Your Ref: Y/49/18/PL

Our Ref: NW/ARU/18/11A

RE Land East of North Road Yapton

Thank you for your correspondence of 18th August 2018, advising me of a Development of 10No.residential properties & associated infrastructure. This application is a Departure from the Development plan and you seek advice from a crime prevention viewpoint.

CYCLE STORE				
scale	date	job no.	dwg no.	rev.
1:50 @A3	MAY 18	1706	2.14	-

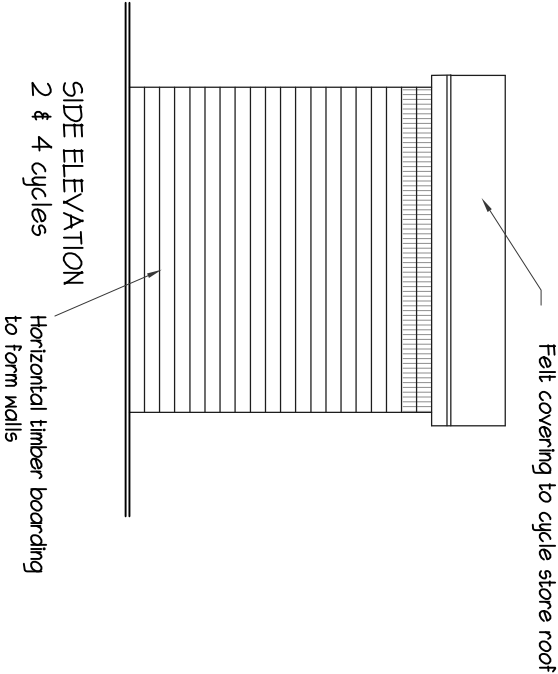
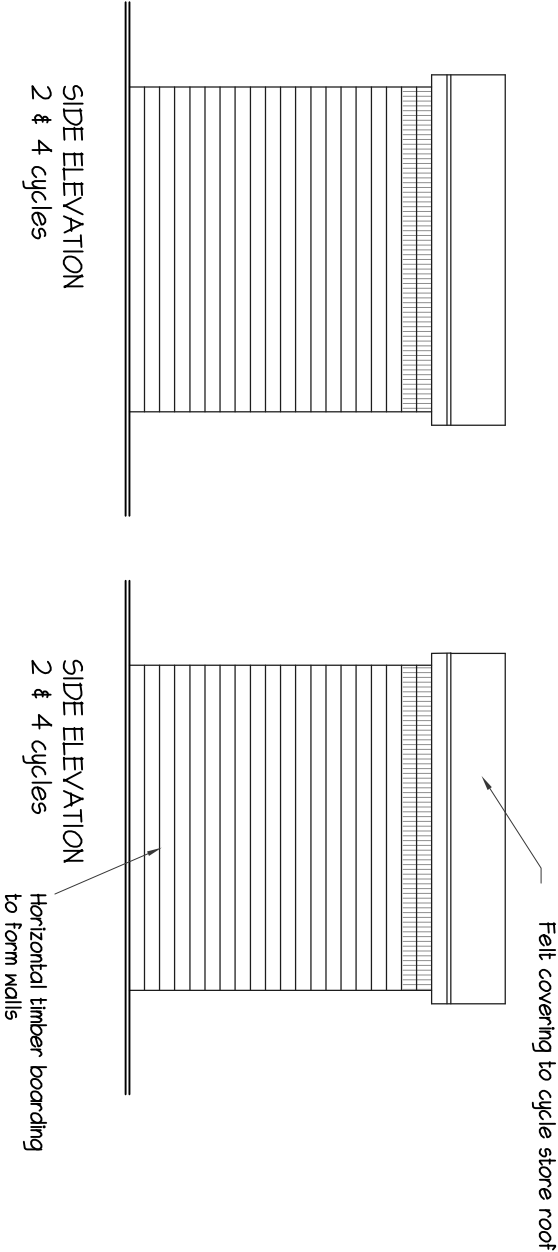
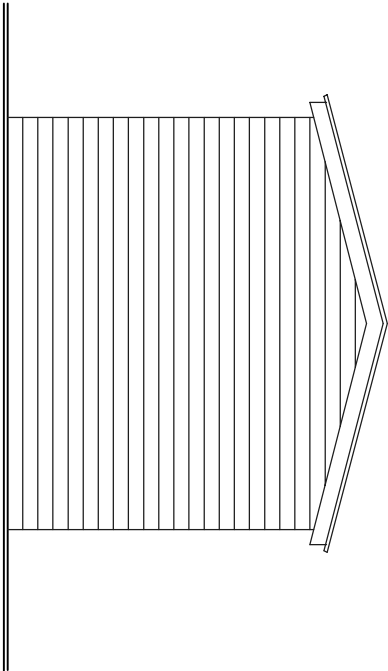
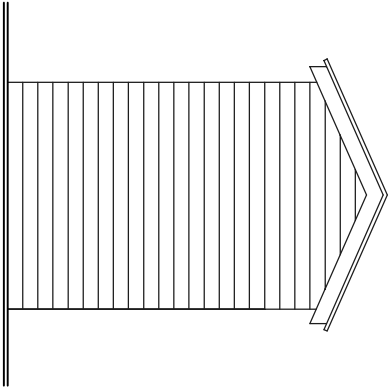
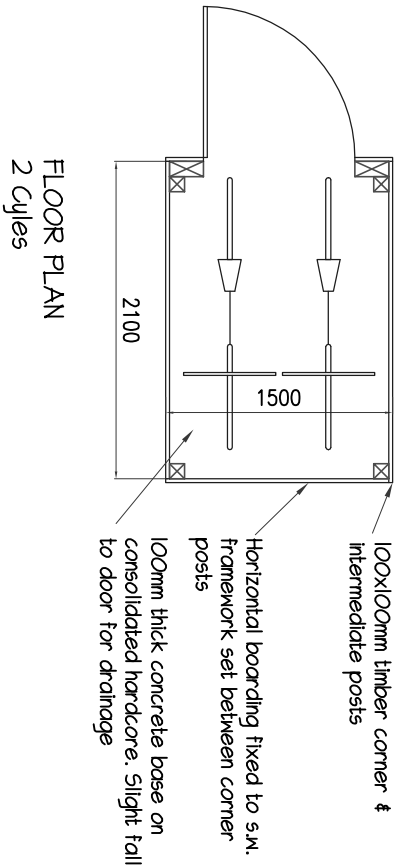
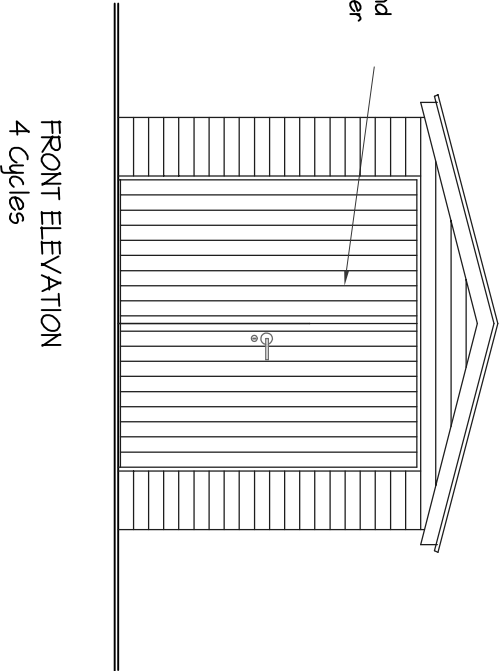
Given that the proposed 4 cycle store has double doors, a door closer is to be fitted along with spring loaded automatic shoot bolts to the unlocked door to ensure it closes first. I would also recommend that communal cycle stores are fitted with a thumb turn lock on the inner face to prevent accidental locking in by another person.

If used after dark they should be fitted with vandal resistant dedicated energy efficient lighting.

SITE PLAN

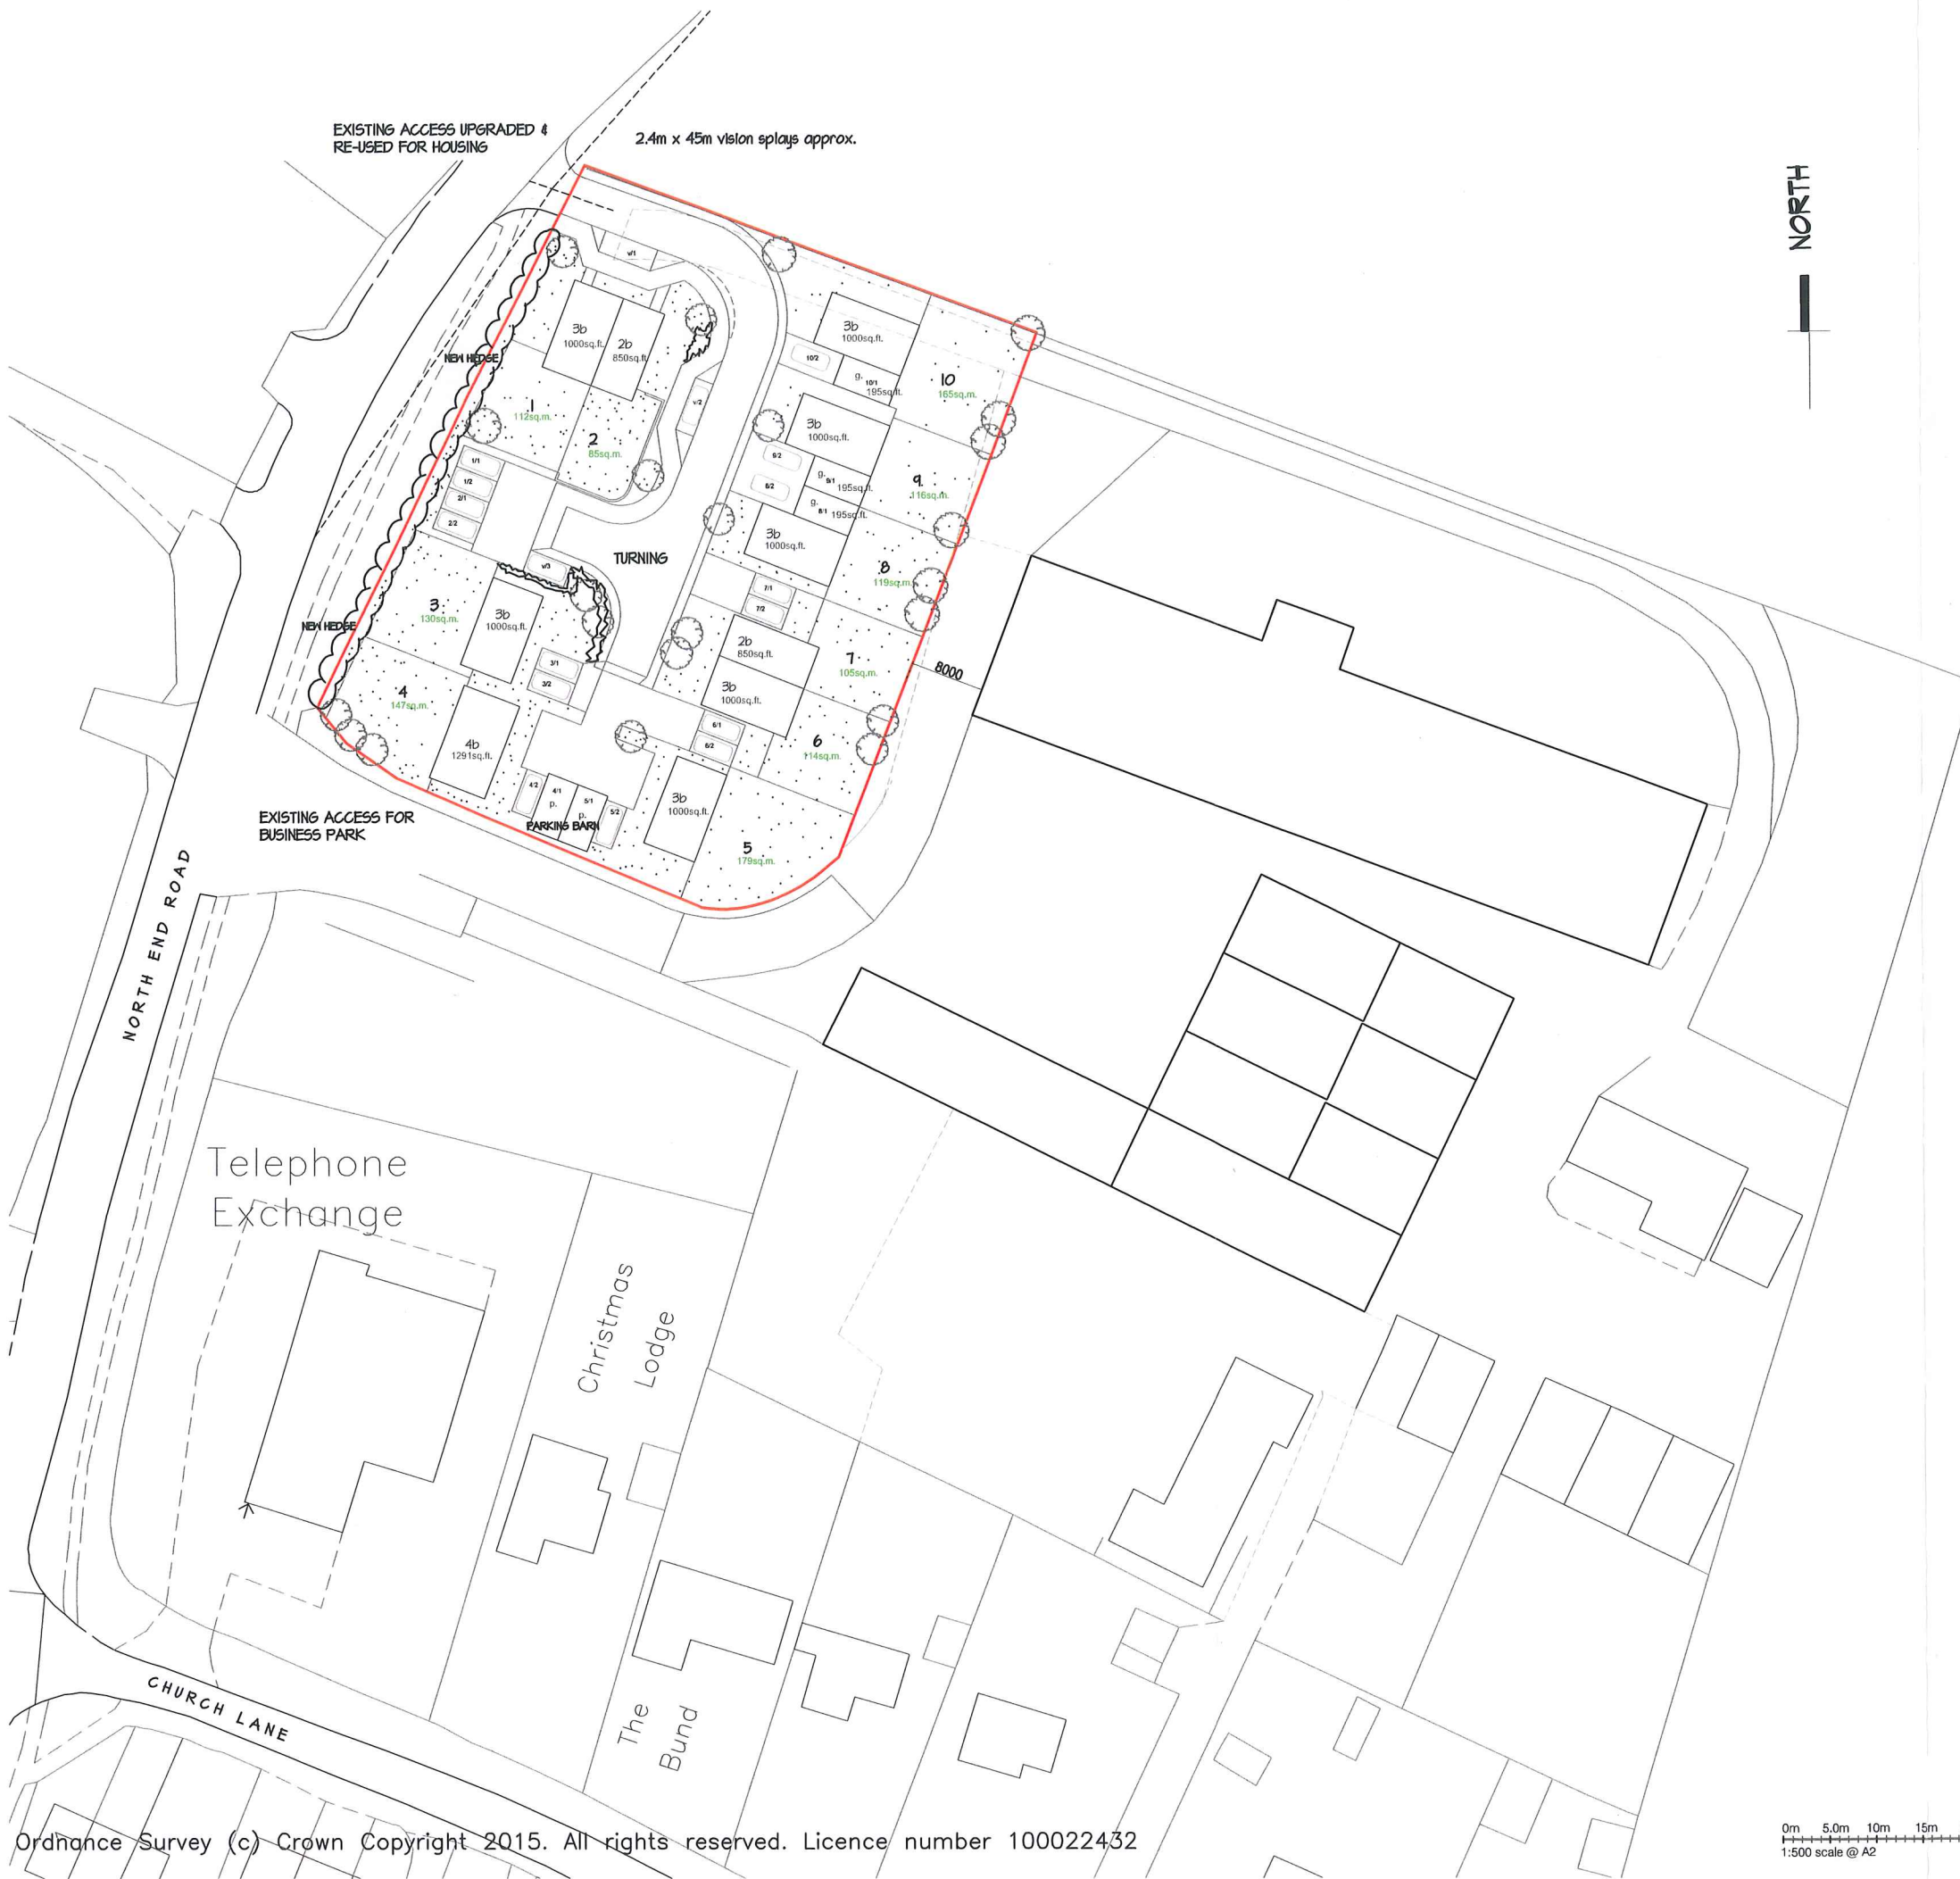
The development has outward facing dwellings which has created a good active frontage with the street. The public areas are overlooked. This design has eliminated the need for vulnerable rear garden pathways. Parking in the main has been provided with in-curtilage, garage & car barn parking and a number of on street parking bays, this should leave the street layout free and unobstructed.

I am pleased to see 1.8m high fencing around the perimeter of the development and enclosing the back gardens. This is important at all times but especially if there is unrestricted vehicle access to the driveway of the Orchard Business Park located immediately behind the development. More so when it is closed and at night, as it provides an unobtrusive and convenient place to park a vehicle and commit crime, potentially via the back gardens of the properties if there is not sufficient perimeter security.
